CITY OF ALBUQUERQUE

RE: **Car Crafters**
5600 Holly Ave NE
Request Permanent C.O. – Accepted
Engineers Stamp Date 1/29/15 (C18D044)
Certification Dated: 3/30/16

SUBJECT: CAR CRAFTERS (C23/D044)
Engineer's Certification of Grading & Drainage for Permanent Certificate of Occupancy

**CAR CRAFTERS  
GRADING AND DRAINAGE PLAN  
ALBUQUERQUE, NM  
PROJECT #14-032**

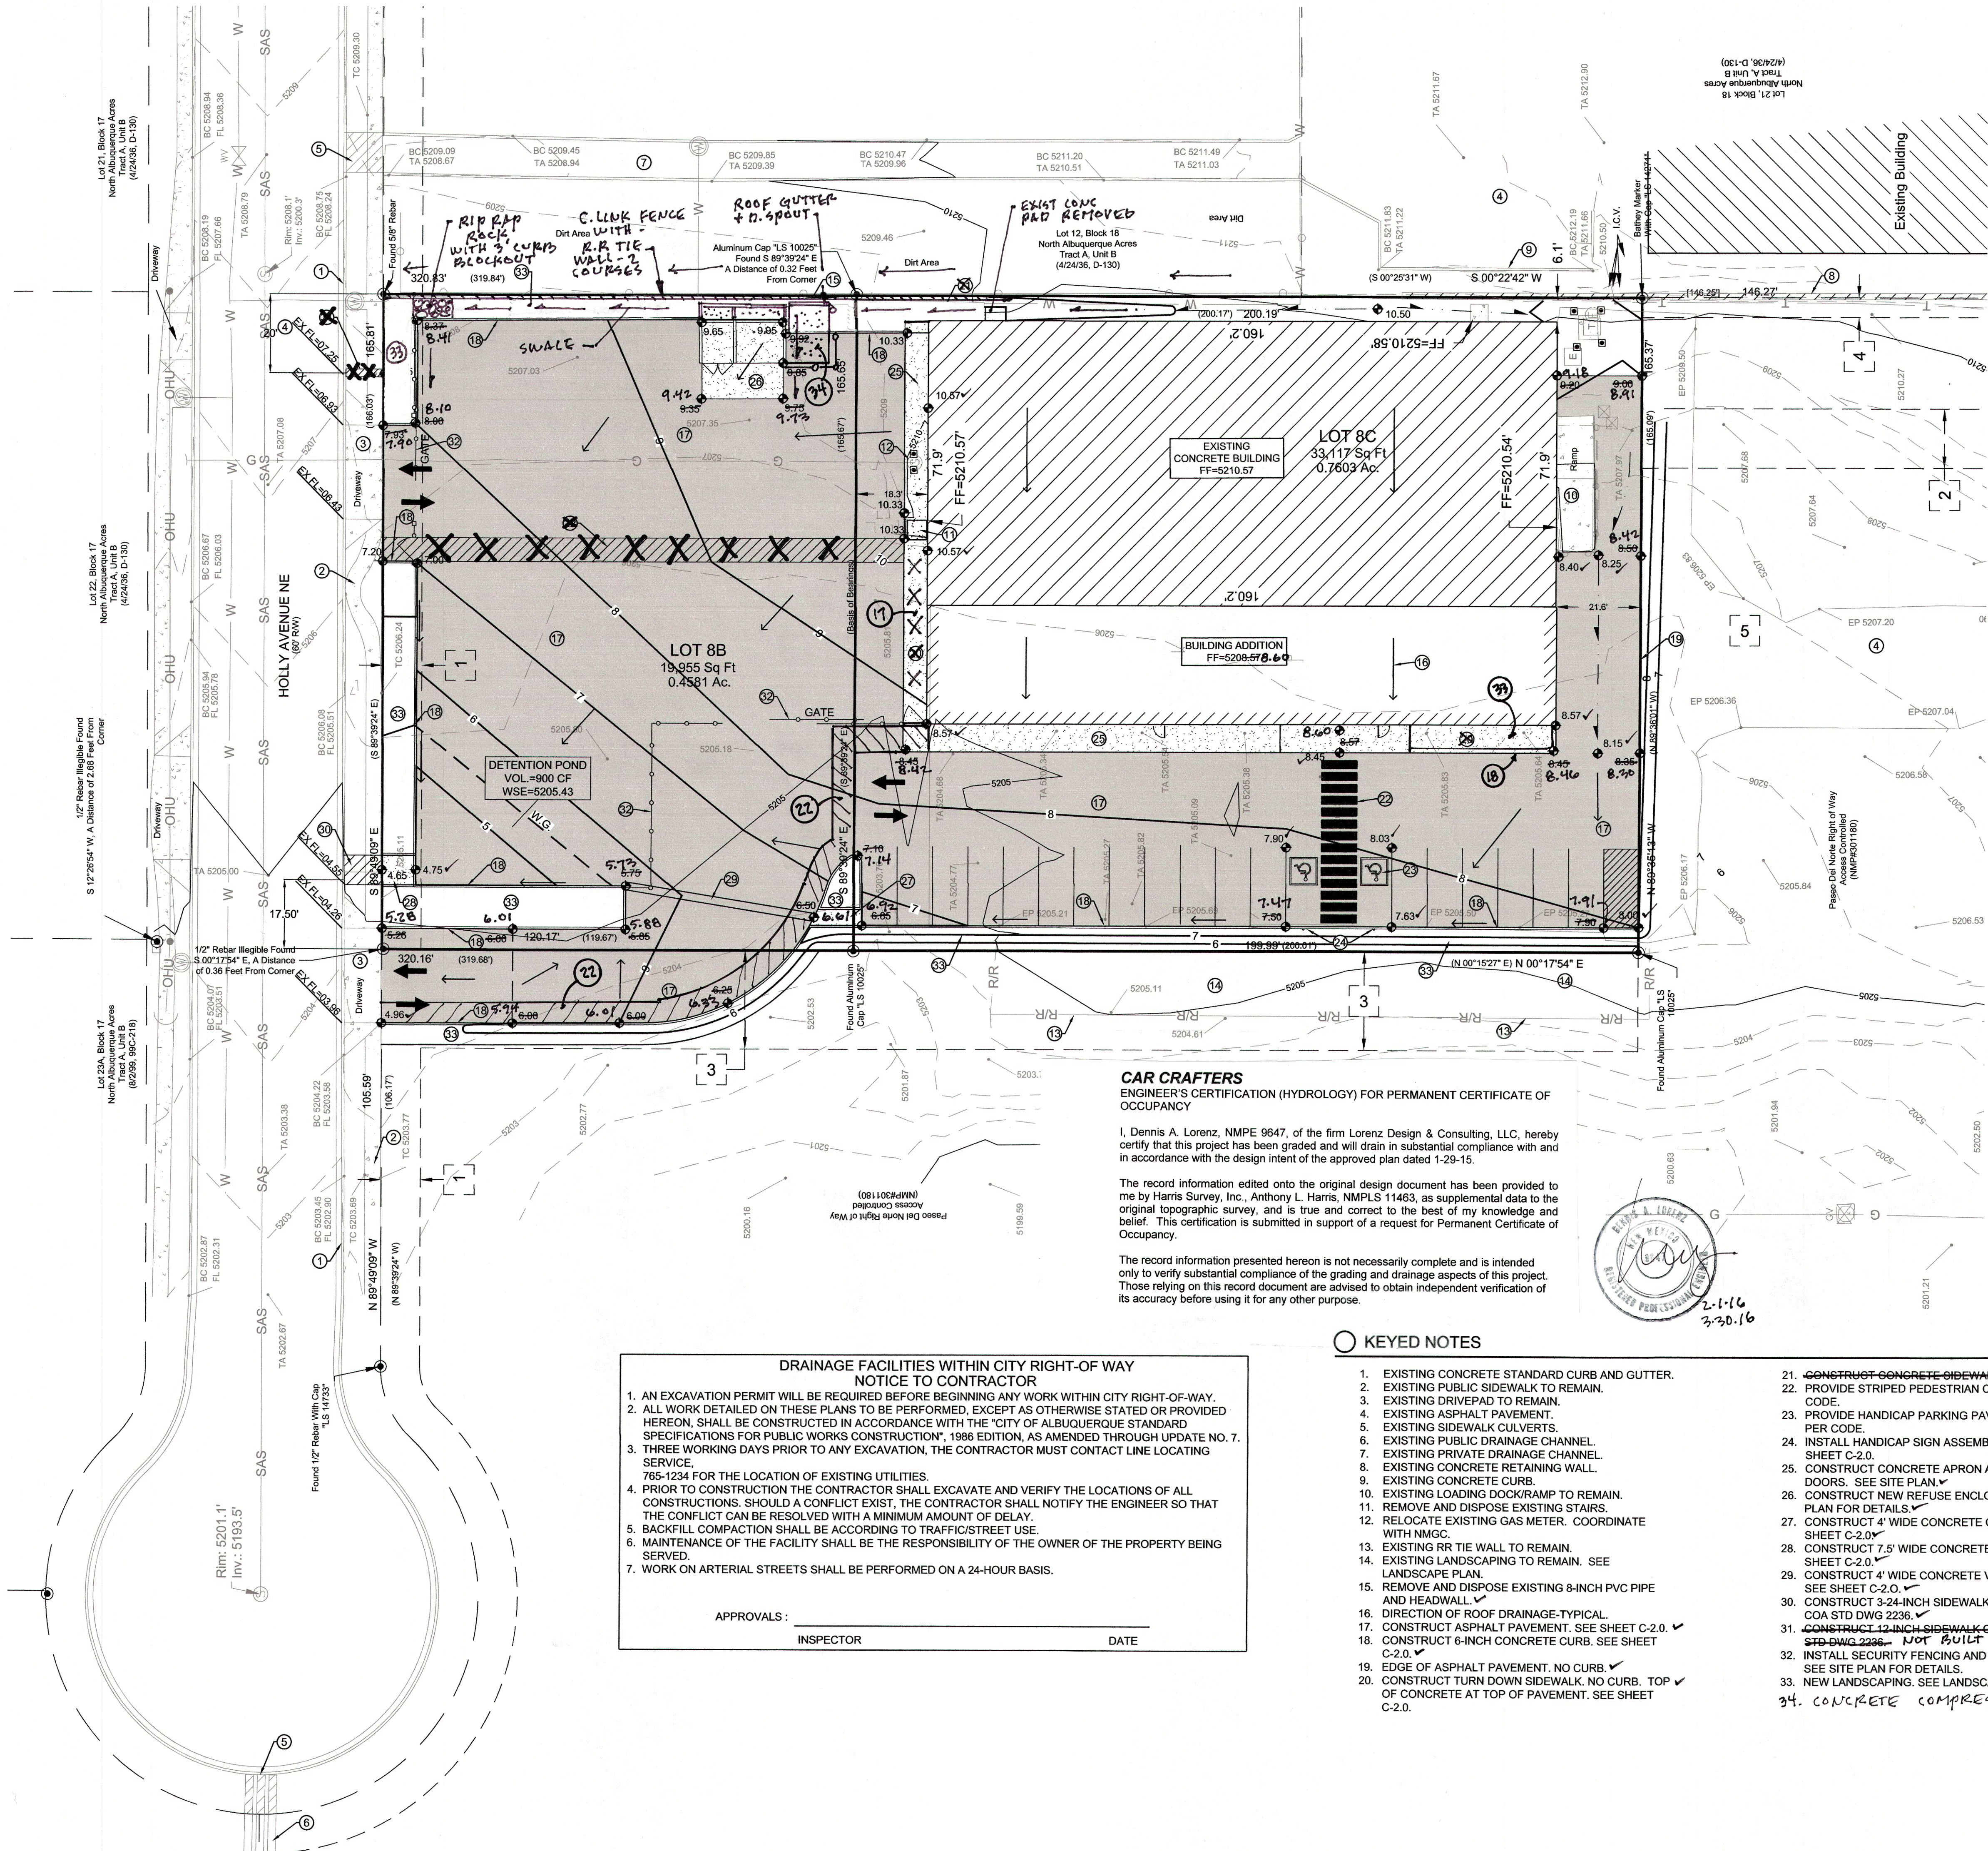
- On the east side of the building define swale to ensure that it does not discharge water to the adjacent site.
- Remove portion of stoop on east side of building so that it does not extend underneath the fence on to the adjacent site.
- Starting north of the above mention stoop, water draining north is blocked by the stoop. The swale does not exist from the stoop all the way to the NE corner and turning west at the fence corner. The swale must be defined so that water does not discharge to the adjacent site or the sidewalk north of the site. Overflow must be routed thru a sidewalk culvert.
- Provide new drainage calculations for 3'-7" channel on key note #27. The drawing calls out 4'-0".

- On the east side of the building define swale to ensure that it does not discharge water to the adjacent site.
- Remove portion of stoop on east side of building so that it does not extend underneath the fence on to the adjacent site.
- Starting north of the above mention stoop, water draining north is blocked by the stoop. The swale does not exist from the stoop all the way to the NE corner and turning west at the fence corner. The swale must be defined so that water does not discharge to the adjacent site or the sidewalk north of the site. Overflow must be routed thru a sidewalk culvert.
- Provide new drainage calculations for 3'-7" channel on key note #27. The drawing calls out 4'-0".

Submitted herewith in support of Permanent Certificate of Occupancy approval is one copy of the Engineer's Certification of the Grading and Drainage Plan for the subject site. The certification has been amended to add as-constructed information describing the drainage swale along the east property line. The following improvements were made:

1. The concrete pad and drainage line have been removed at the northeast building corner.
2. A railroad tie retaining wall, approximately 2 courses high, with a 6' chain link fence was constructed along the east property line.
3. The roof over the compressor pad is equipped with a gutter and downspout draining roof water to the yard swale.
4. A swale was constructed behind the building draining north to the compressor pad. Swale flows drain through the compressor pad and are directed west to the paved parking lot by the refuse enclosure wall. This situation is not ideal, but excess runoff is expected to be minor since the swale only drains flow from the swale itself and the compressor roof.
5. The swale north of the refuse enclosure drains to a rip rap erosion control pad before existing to the paved parking lot.

1. The bigger issue here is the unmanaged runoff that enters our property from the undeveloped property to the east. The property is littered with trash and construction debris, not to mention the large dirt stockpile that becomes airborne when the wind blows. Field conditions and differences in the topographic survey along the property line have made it impossible to construct the swale that we recommended within the landscape area along the east property line. The best we can do is maintain a swale along the fence line then build a curb and gutter section (see attached) to capture as much runoff as possible and drain it to the parking lot. When the adjoining property develops this drainage issue will be permanently remedied, but for now we are doing the best practical thing we can.

2. The existing stoop is not a drainage improvement and will be trimmed if required by Zoning.
3. The existing 8-inch storm drain will be cleaned and the swale re-graded to drain the area south of the stoop.

4. Calculations are provided demonstrating capacity of the channel that was built narrower than recommended.
